114 Harris Ave. - Permit 2016-02914

I have done the initial zoning review for the sunroom that was built "on the existing porch". At this point I cannot approve the permit for zoning.

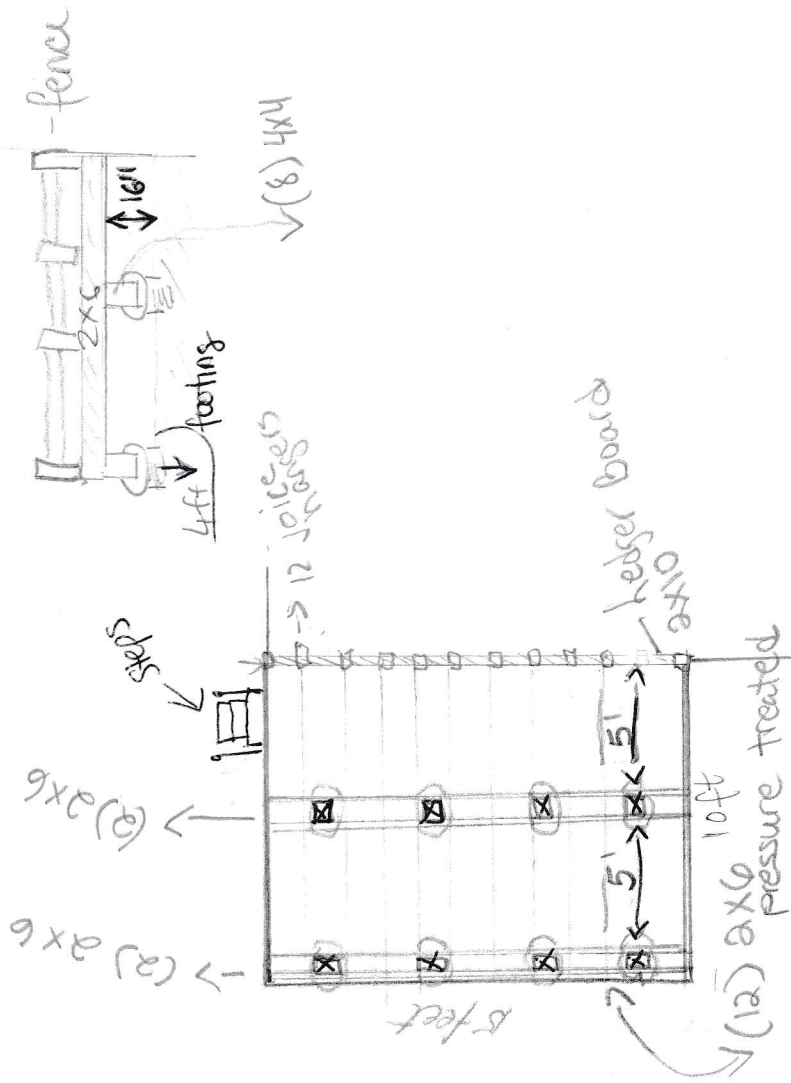
The property is in the R-3 zone. The side yard setback for a one story addition is 8 feet. The plot plan shows the setback to the house as 18 feet and the deck coming 15 feet off the side of the house. That leaves an 6' side setback which does not meet zoning. There is no permit on file for a 12' x 15' deck.

The deck needs to meet the 8' side setback. Please submit a revised building permit application page and a revised plot plan that shows the size of the deck and the setback. Also submit plans that show how the new deck is being built.
